**YELLOWSTONE TRAIL ESTATES PLAT (LP-09-00006)  
RESOLUTION NO. 2010-087  
COMPLIANCE DOCUMENT**

# YELLOWSTONE TRAIL ESTATES

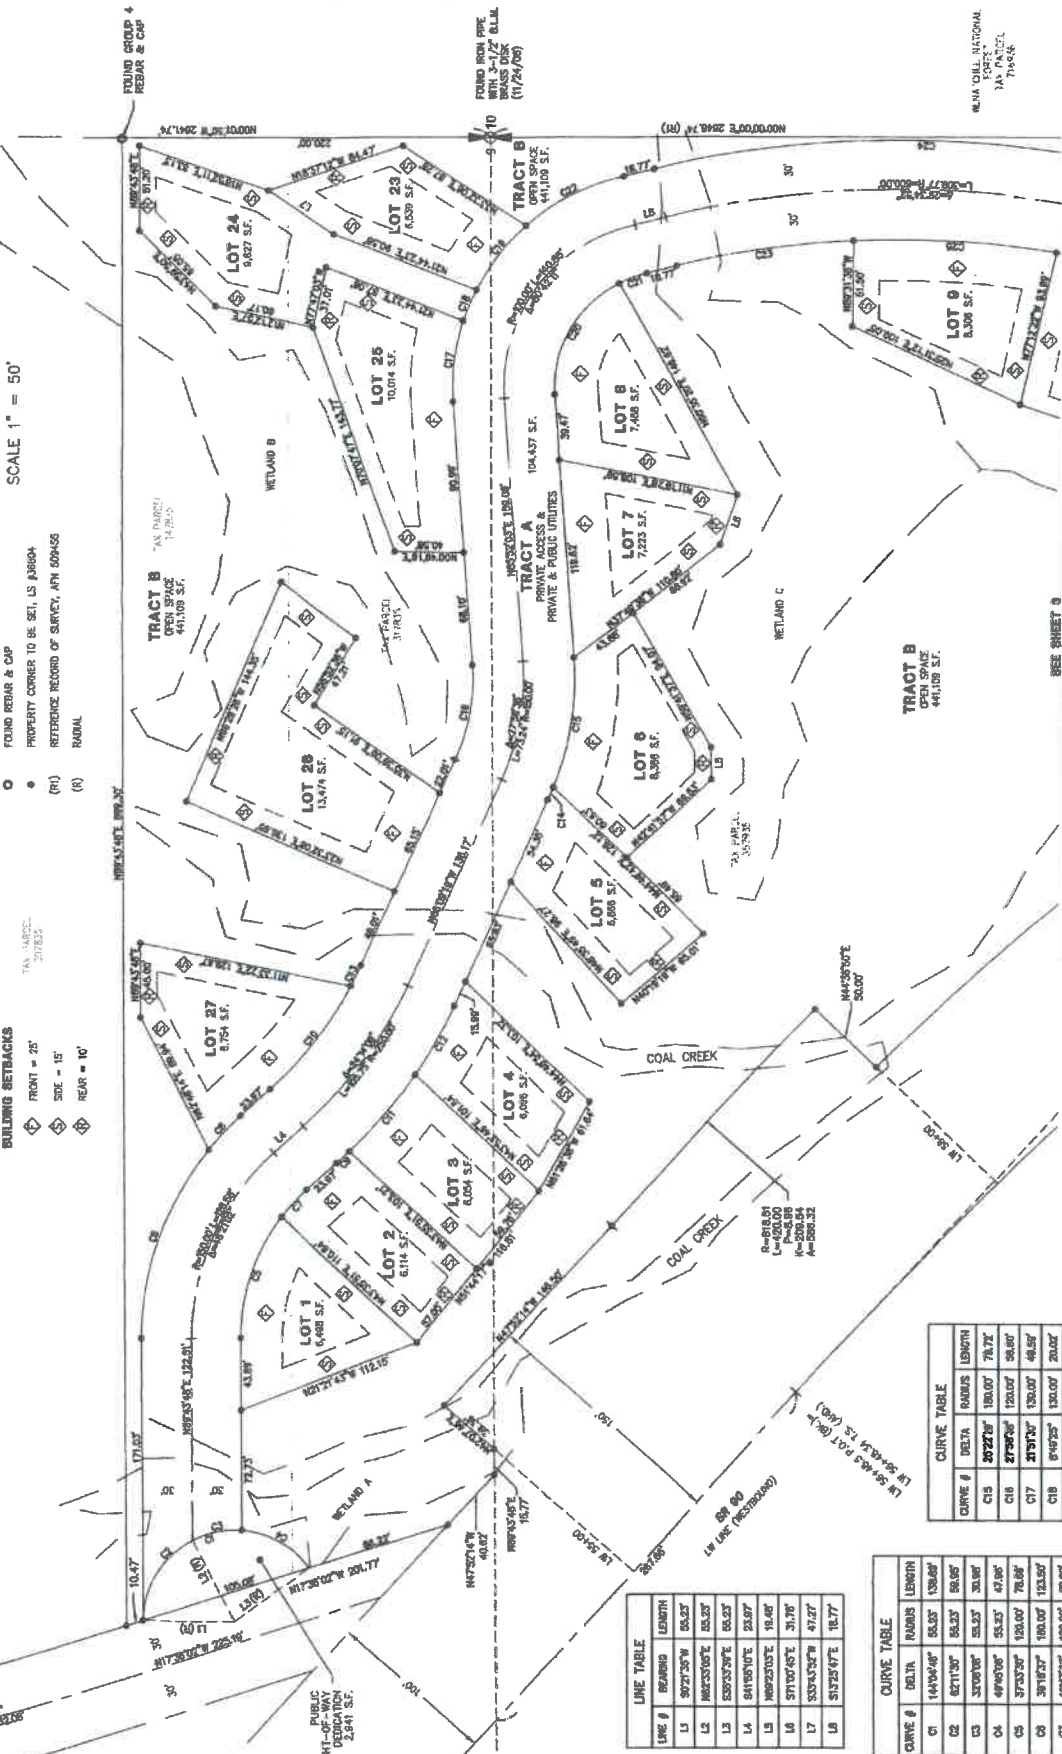
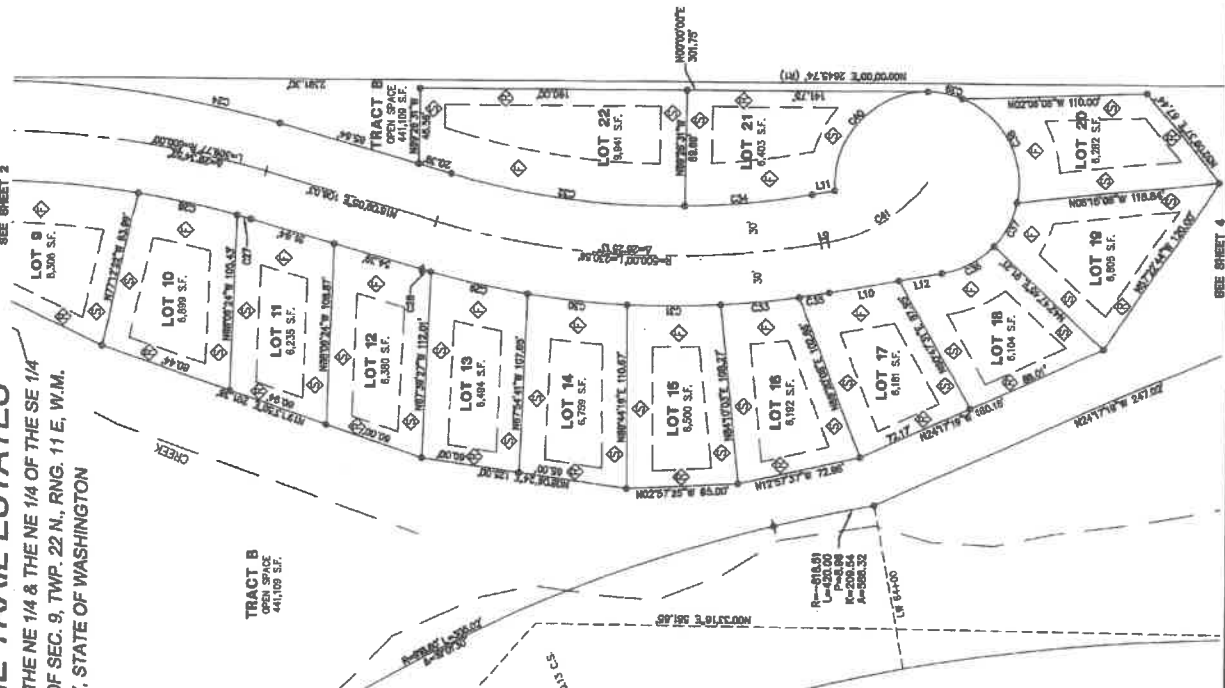
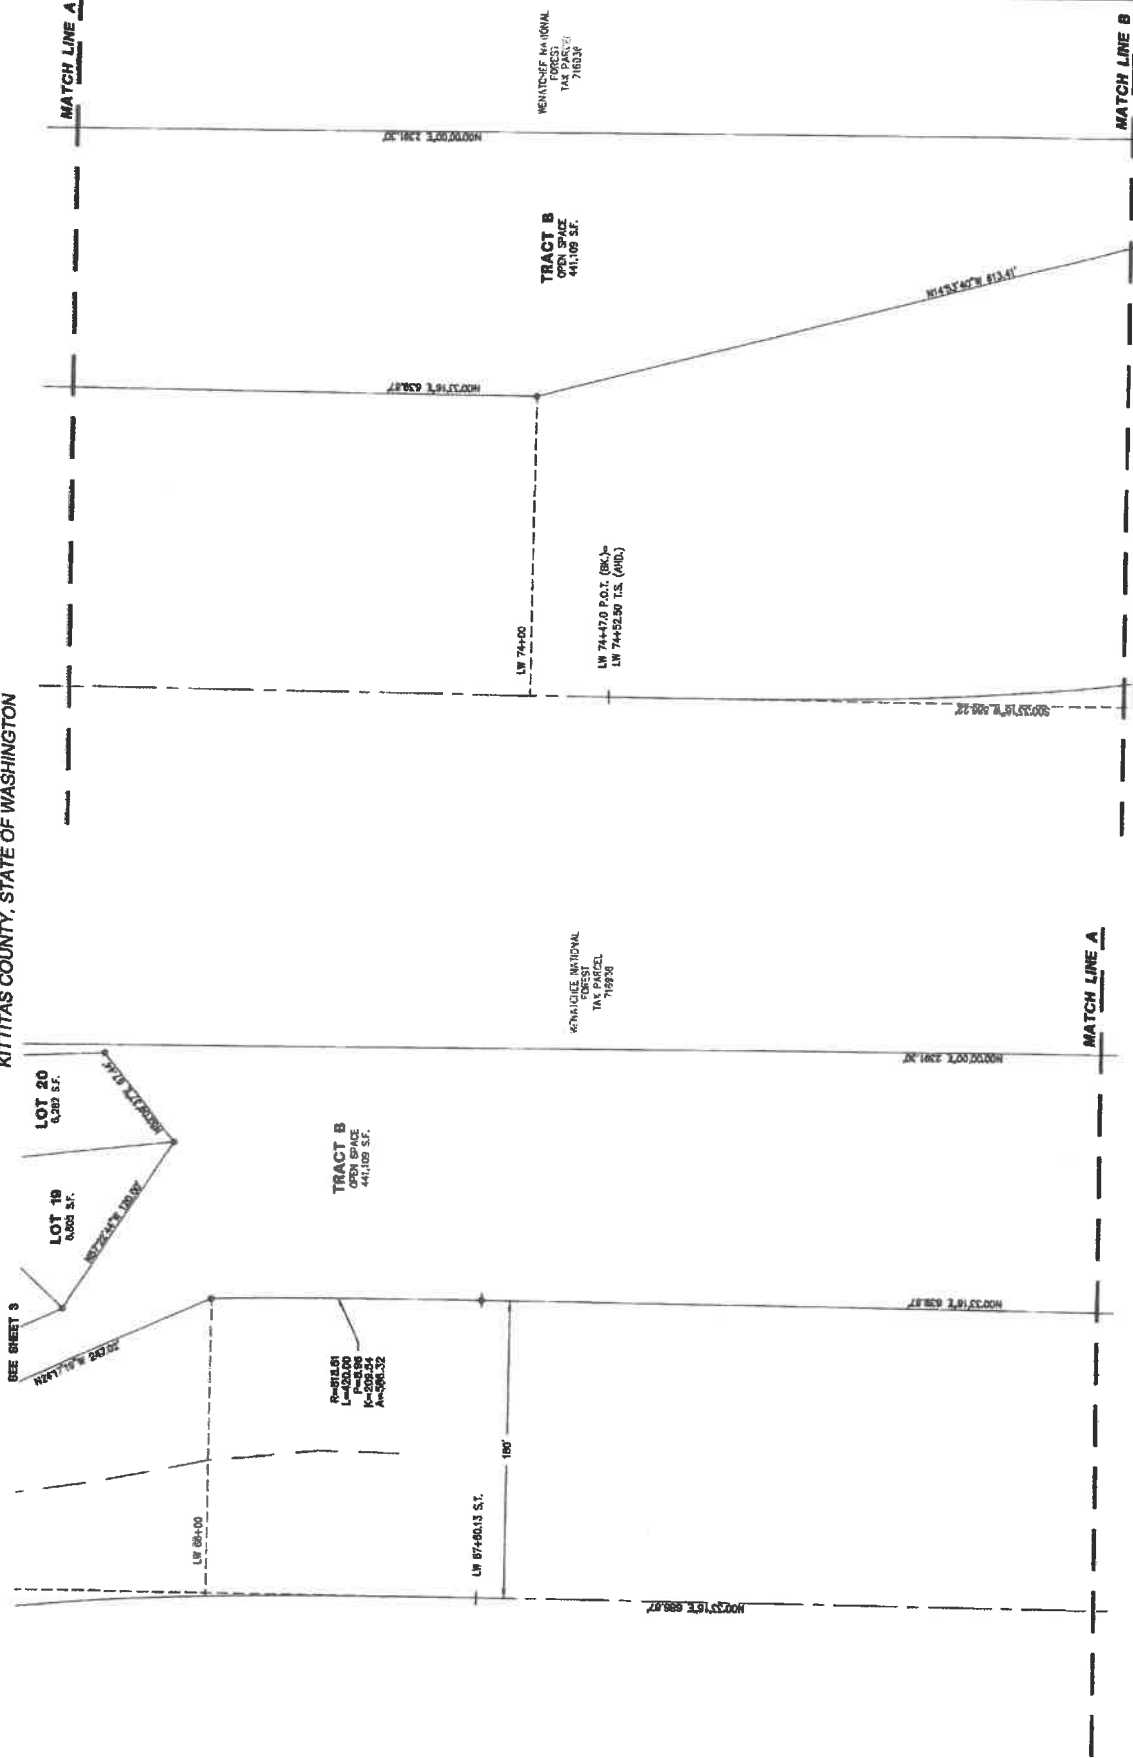
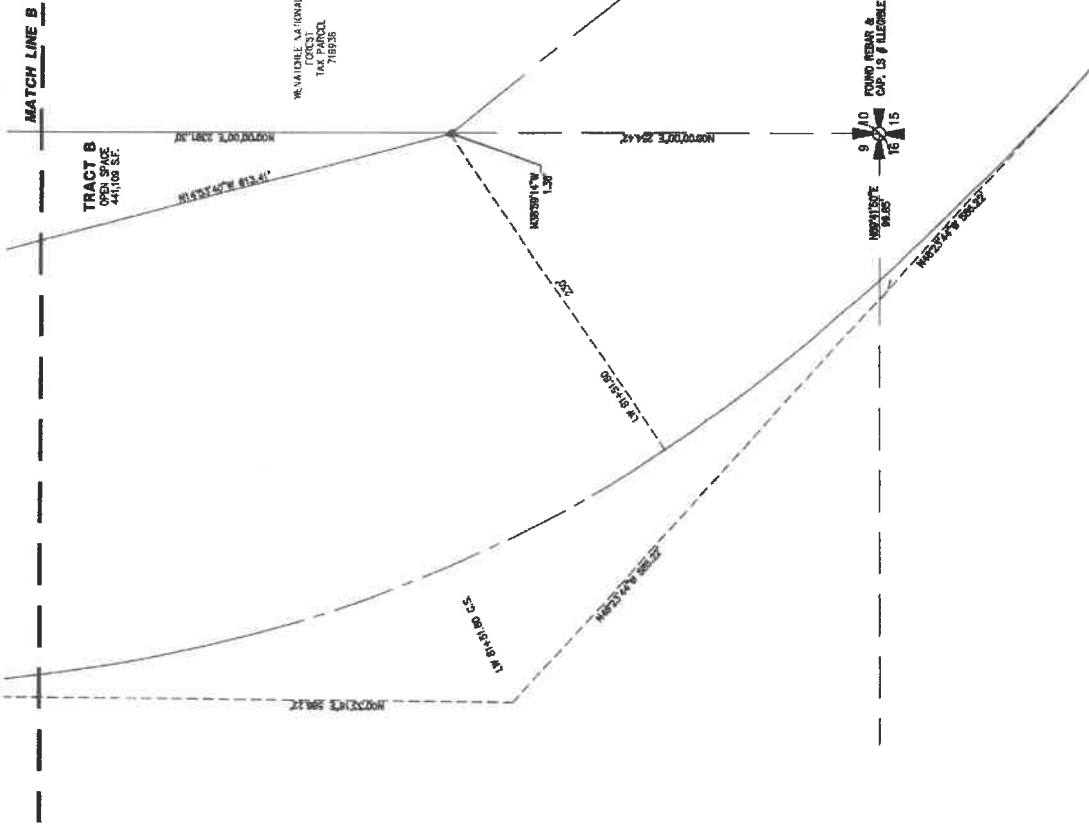
12	Private Road Certification	Offsite road certification will be submitted to KCPW for approval. Onsite road certification to the 9/6/05 standards will be completed after construction.	
13	Lot 24 Access	Lot 24 will be adjusted, using space from 25, 23, 22. The driveway will be widened to 20 feet. Please refer to amended plat map attached.	
14	Property Line Corrections	Developer will comply. Please refer to amended plat map attached.	
15	Yellowstone Road Cul-De-Sac	Developer will comply, as allowed by proximity to the wetlands.	
16	Private Road Improvements	Developer will comply with 9/6/05 standards, and in cooperation with KCPW. Please see attached amended plat map.	
17	Cul-De-Sac	Developer will comply in cooperation with the fire Marshall, and according to 2006 IFC.

51	Lot 24 driveway and snow removal concerns	Applicant has modified the plat to address driveway concerns.
